Kirklees HDM Interim comments

2021/92206 - K3-49/7 - Land off Woodhead Road, Brockholes

Erection of 137 homes with open space, landscaping and associated infrastructure.

15/02/2022

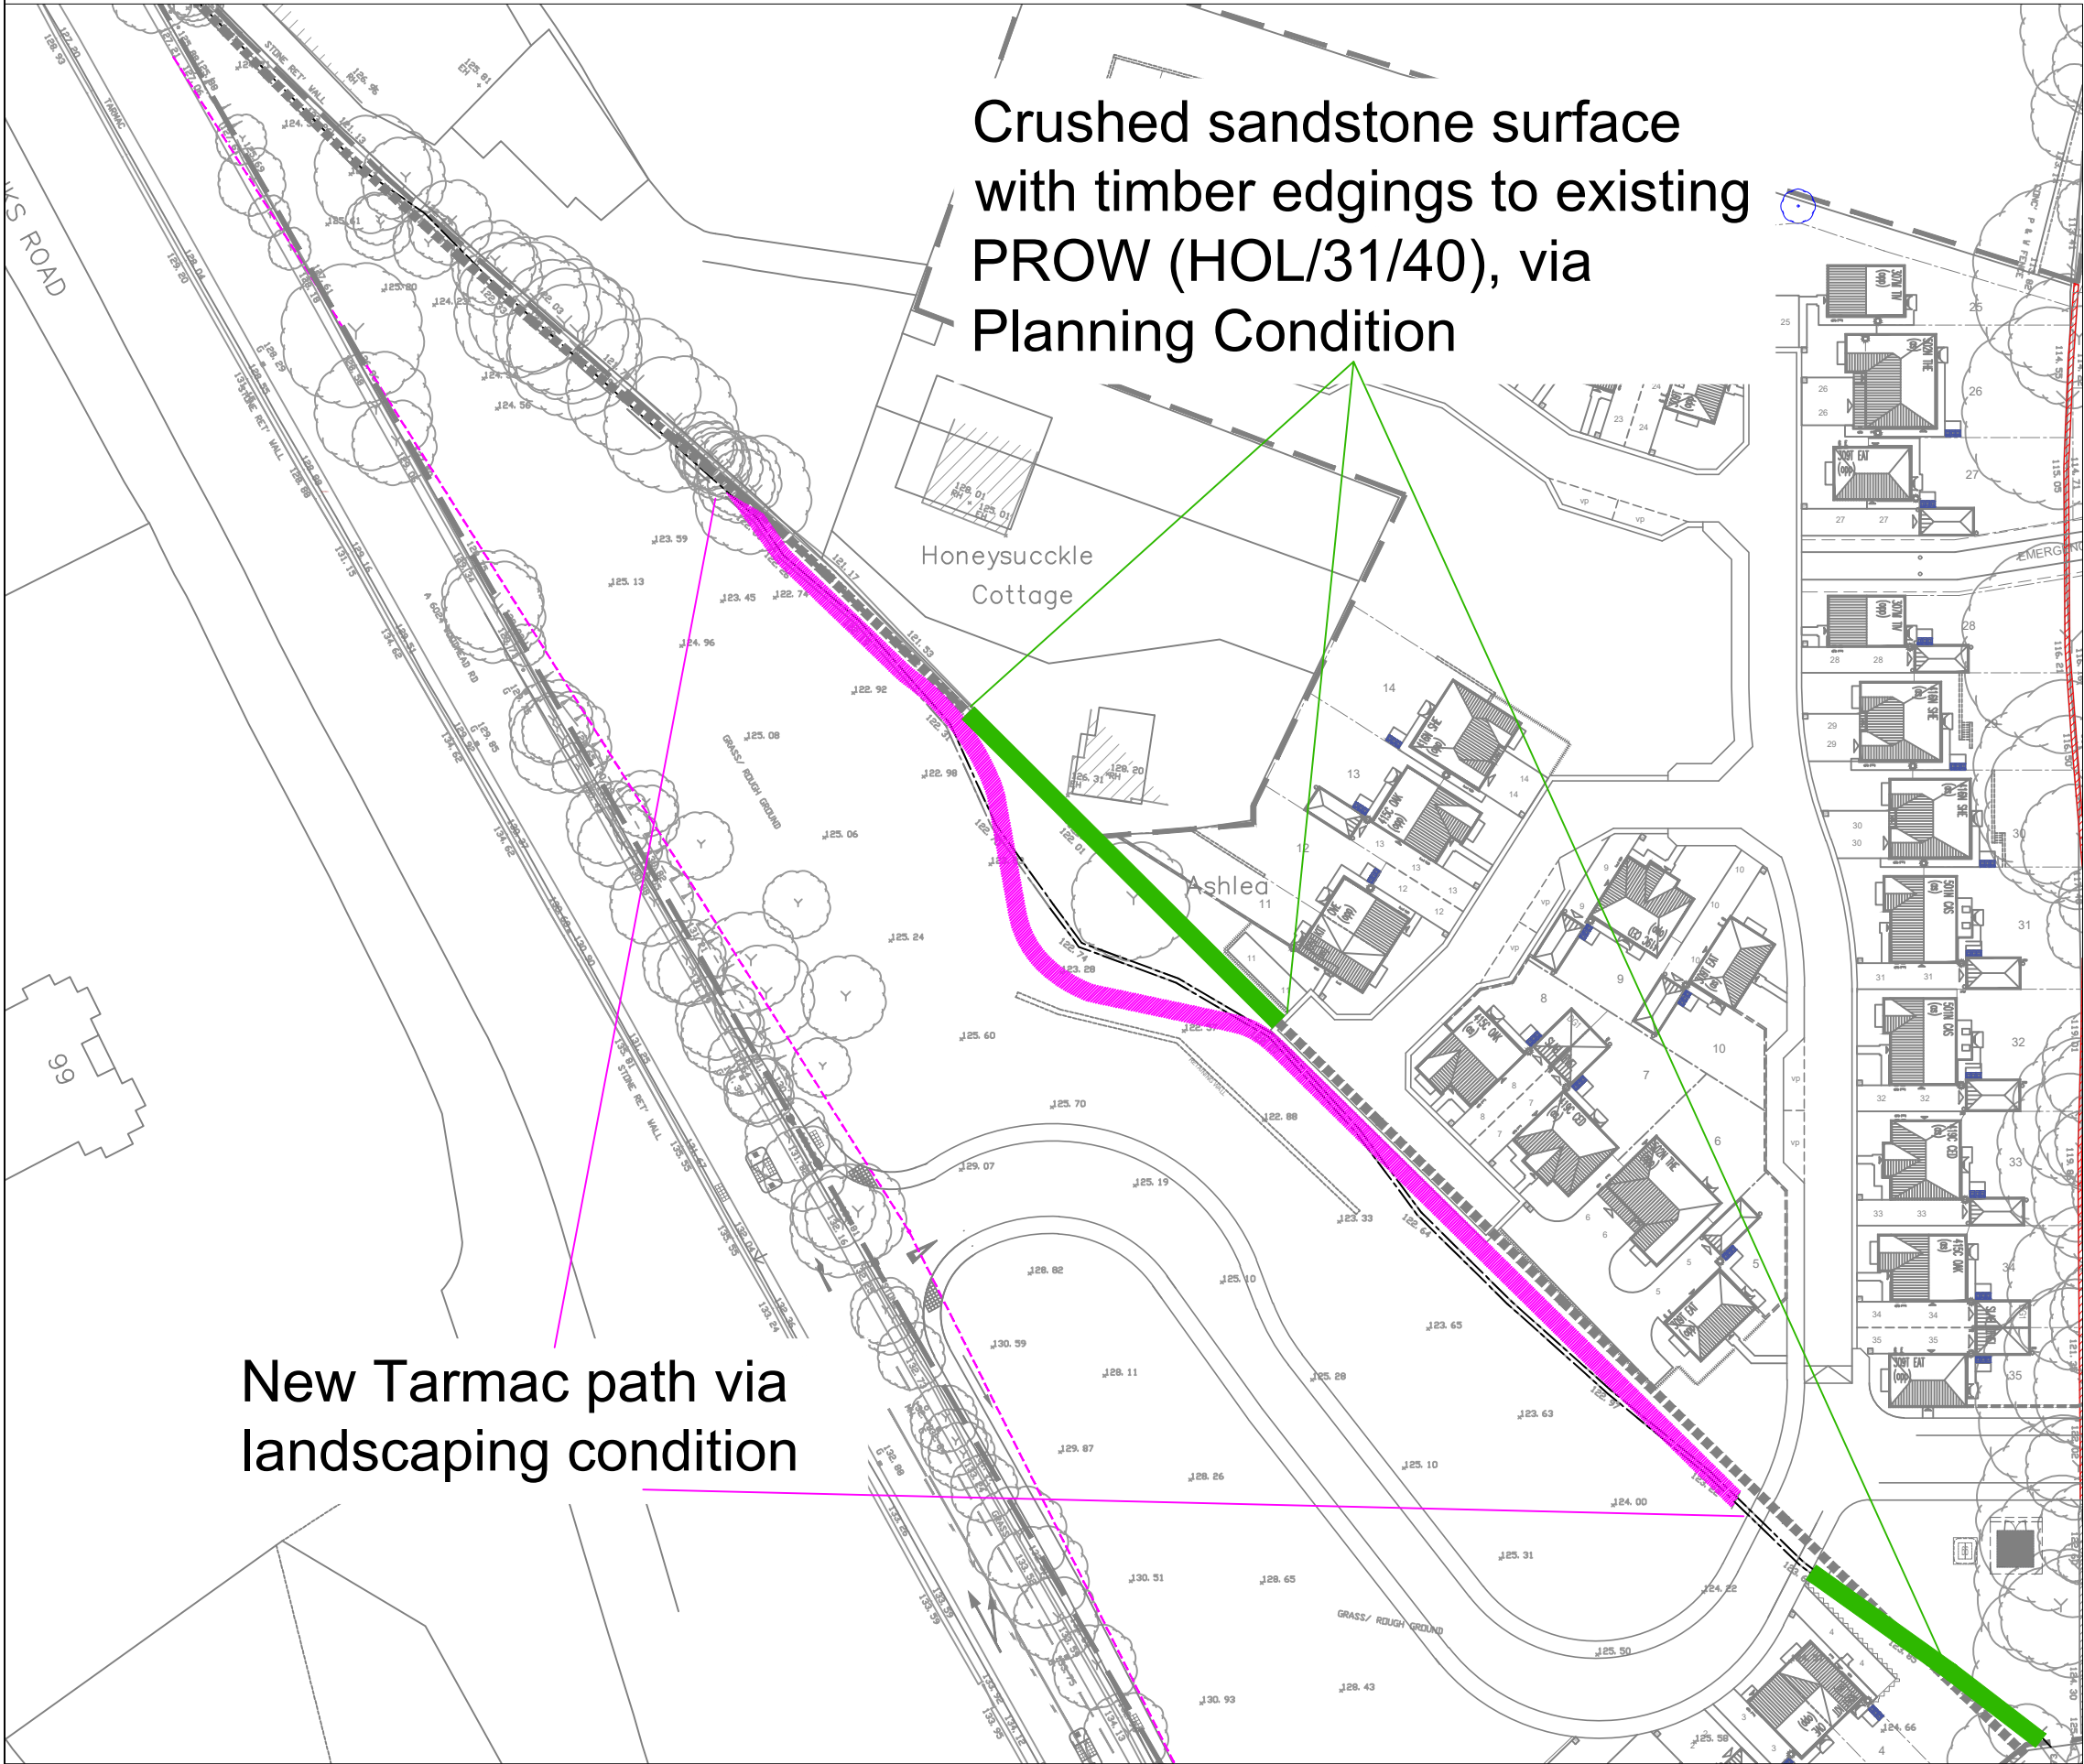
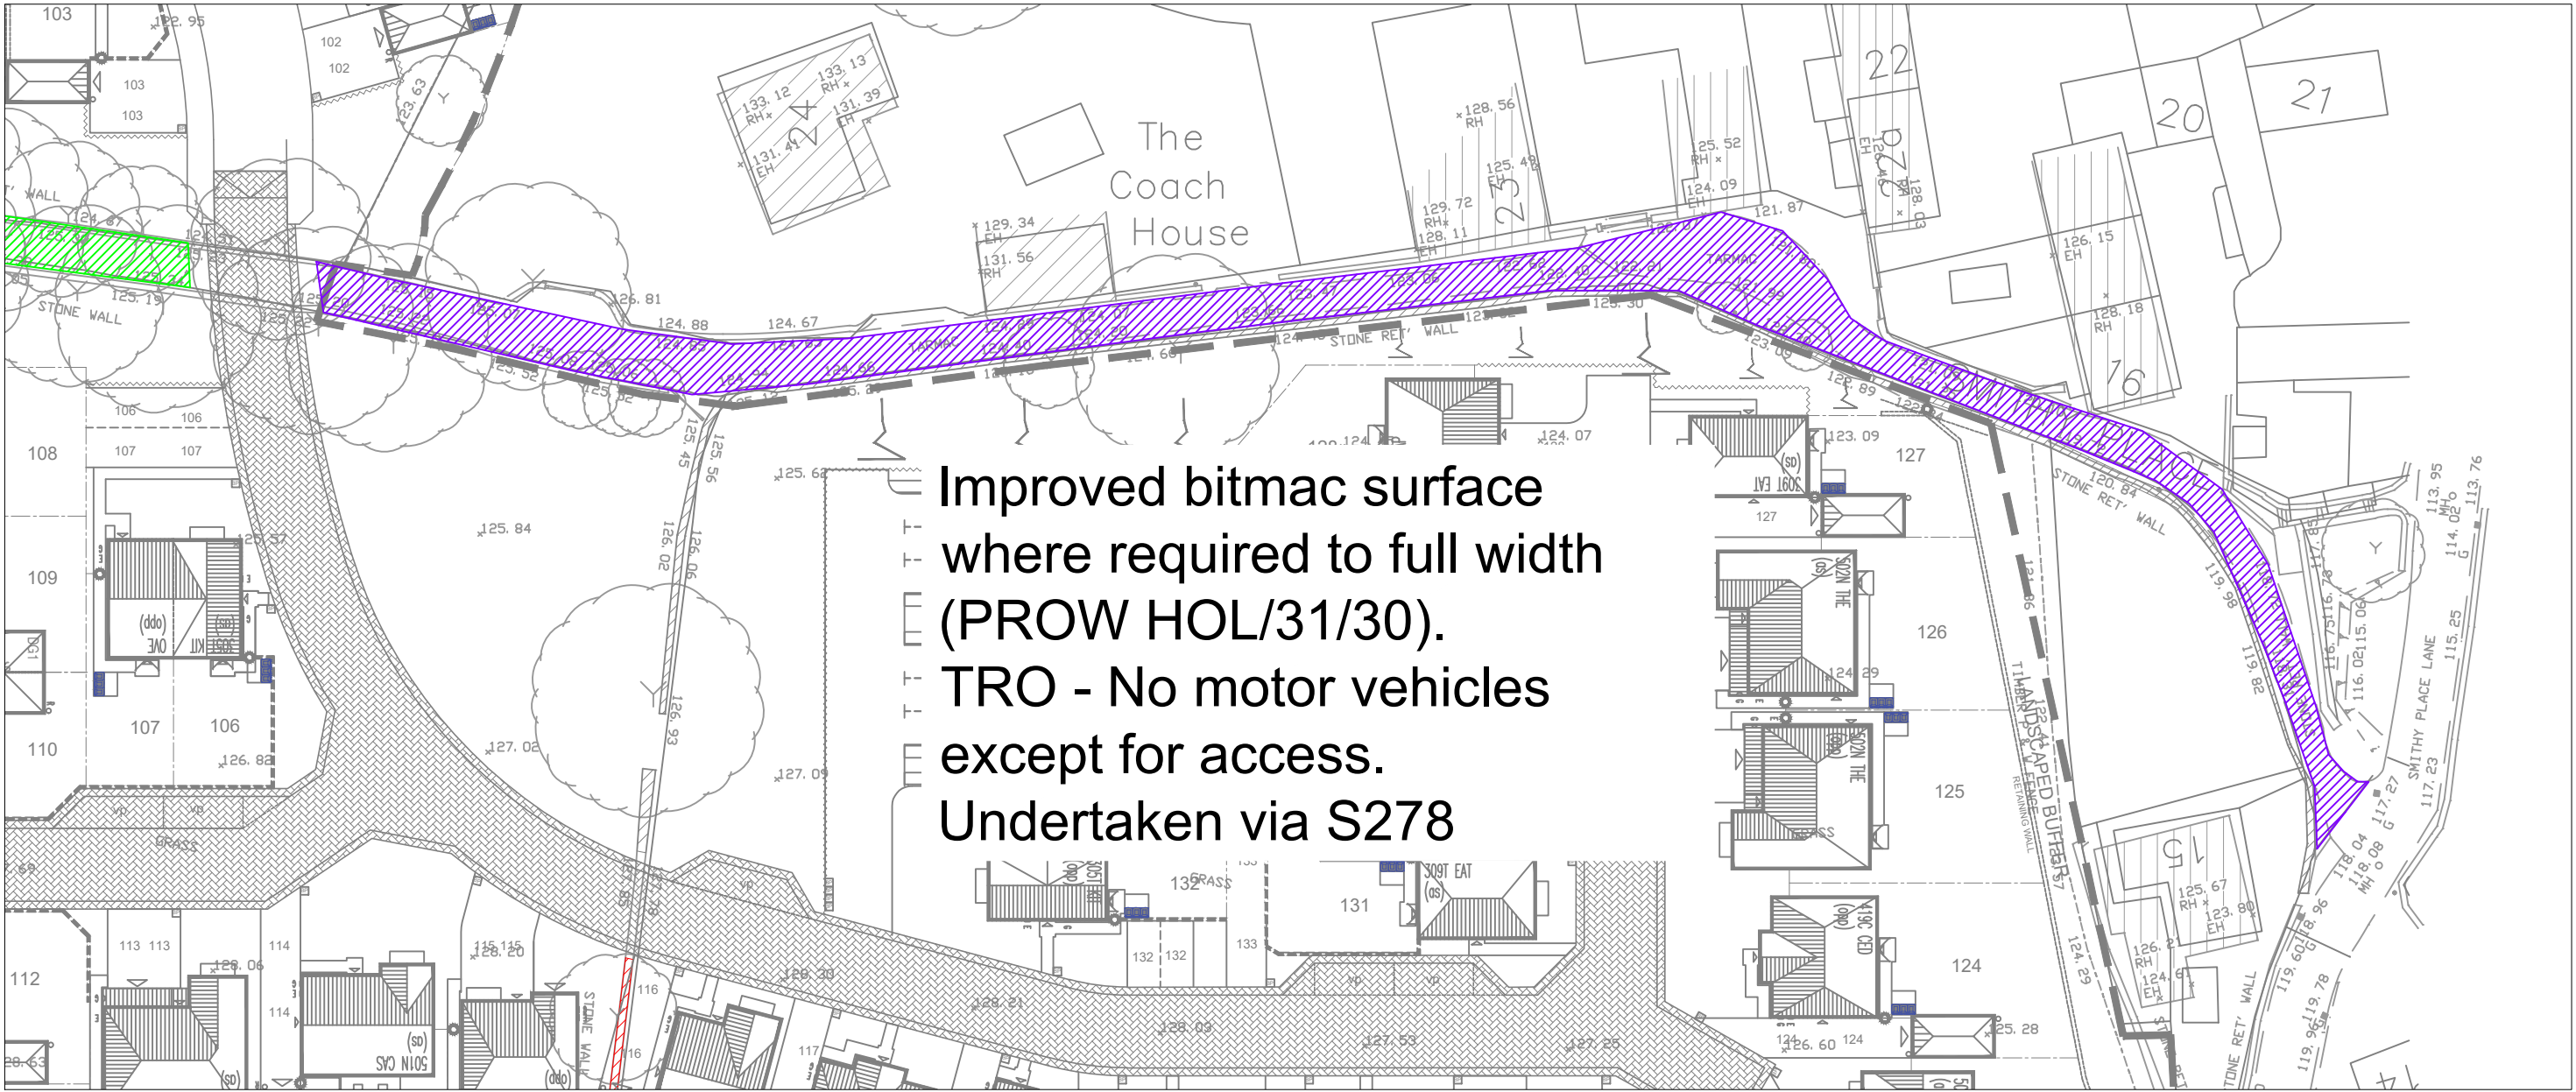
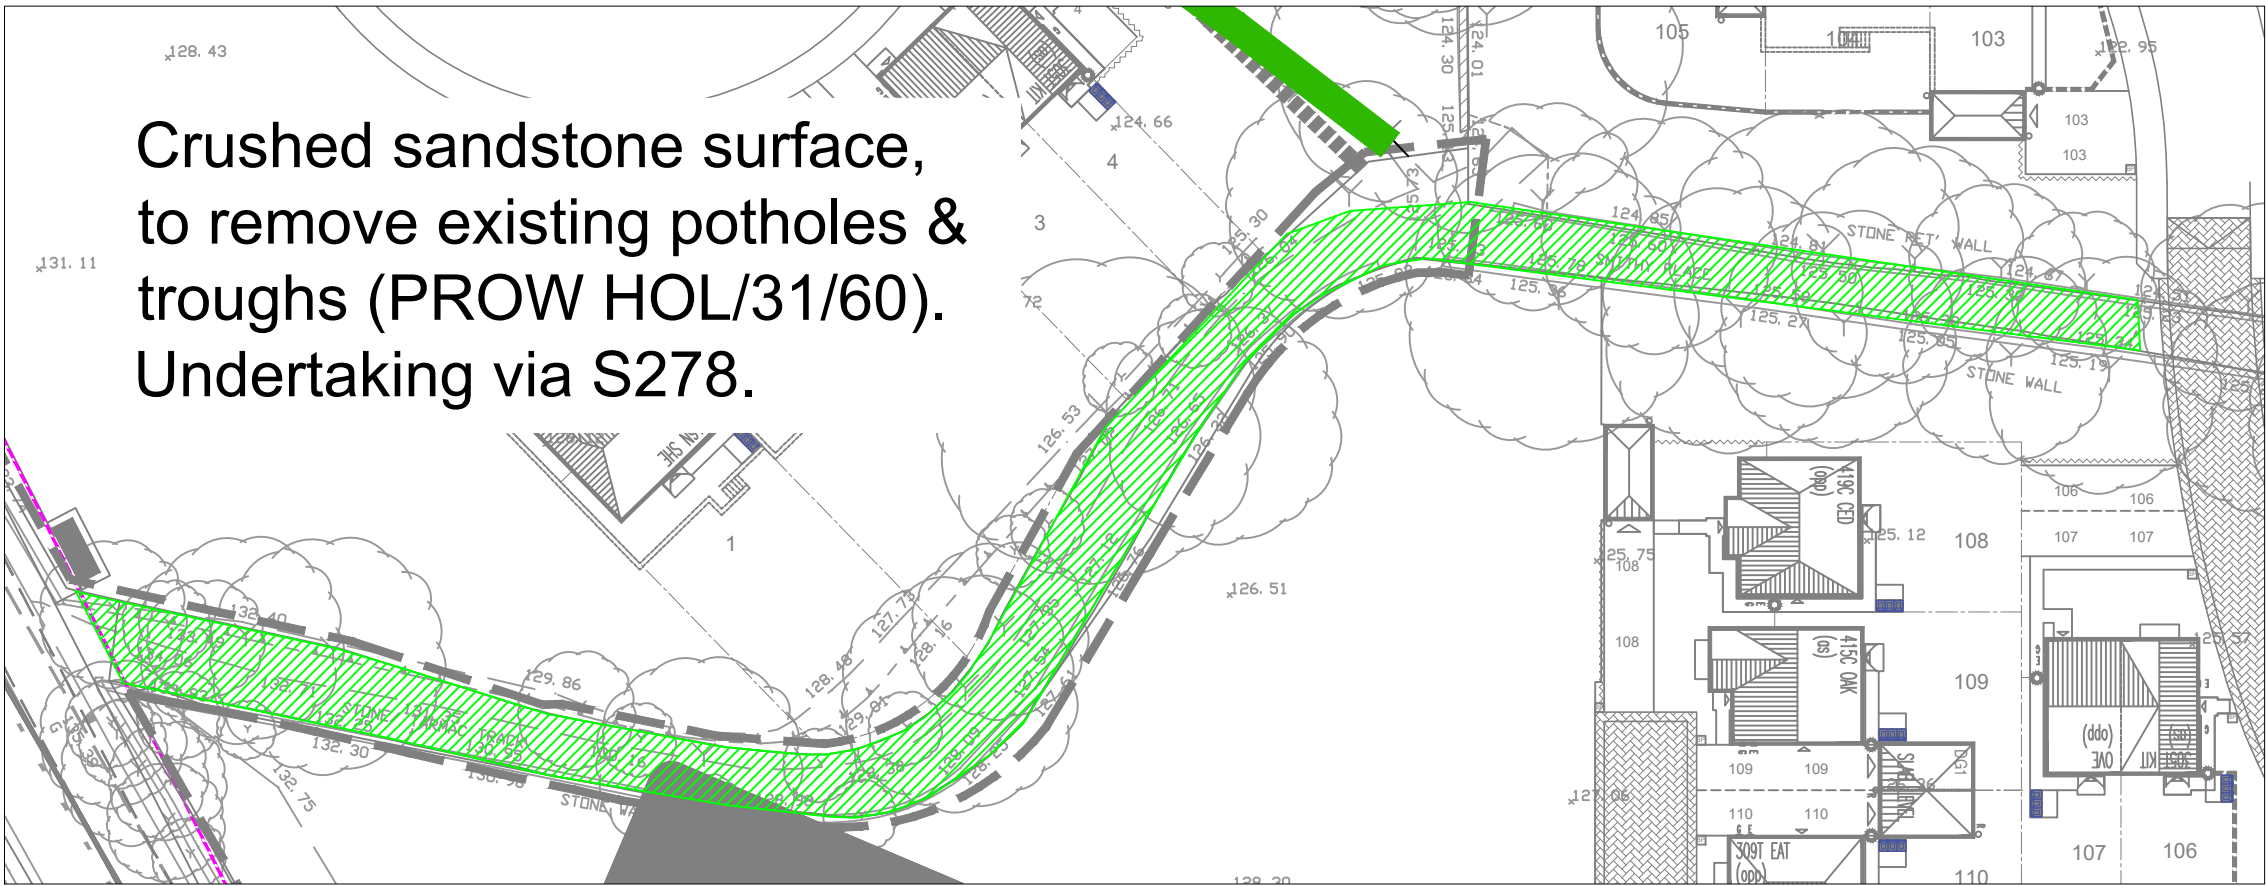
Improvements to the PROW network are required for the footpaths that pass through the site and along Smithy Place. Improvements to Smithy Place are considered to be particularly important and a necessary feature of the development, given that this is the main pedestrian route to/from Brockholes, which is likely to be the primary destination for development users accessing public transport, schools and other local amenities. To provide good quality active travel connections through the site and on the adjacent highway network, the following improvements are requested as a minimum:

- PROW HOL/31/40 that passes through the site should be provided with a crushed sandstone stone surface and timber edging along the line of the definitive rights of way as a minimum. However, along the section of PROW that leads to the play area and trim trail, including the additional route that does not following the existing

PROW, this should be provided with a flexi-pave type construction to allow ease of access for pedestrians with pushchairs or in wheelchairs.

- PROW HOL/31/60 and the section of HOL/31/30 along Smithy Lane (also known as Robinson Lane) between Woodhead Road and the internal access road, should be improved with a crushed sandstone stone surface, to remove existing pot holes and troughs, and rectify and damage caused during construction. No retractable bollards are considered necessary on this section of PROW and it is recommended that these are removed from the site layout plan. These works will need to be secured by S278 agreement.

- PROW HOL/31/30 along Smithy Lane, between the internal access road and Smithy Place Lane should be upgraded, so that an improved bitmac surface is provided for the full width of the track. This needs to provide a suitable surface for all pedestrians (including pushchairs and wheelchair users) and cyclists, as well as continuing to accommodate light vehicle traffic to the existing dwellings. Street lighting should also be provided along this link. These works will need to be secured by S278 agreement.

- The retractable bollard shown to prevent vehicle access to/from Smithy Place to the internal estate roads is considered acceptable in principle. However, a light van turning head is required on Smithy Lane immediately to the east of the bollard, to ensure that delivery vehicles that enter Smithy Lane can turn and exit in forward gear (SPA should be provided to demonstrate this). A 1.0-1.5m gap is also required between bollards to allow pedestrian movement, but prevent motor vehicle access, which may result in only a single retractable bollard being required. Should there be any objections to the retractable bollard(s) from anyone who may have private vehicle access rights along Smithy Place/Robinson Lane that prevent their installation, it will be necessary for a 'no motorvehicle - except for access' TRO to be installed instead, which would need to be funded by the development and secured alongside the S278 agreement.

The above improvements should be shown indicatively on plan, so that the extent and scope of works is agreed. These works would then be secured by condition, and implemented by a S278 agreement.
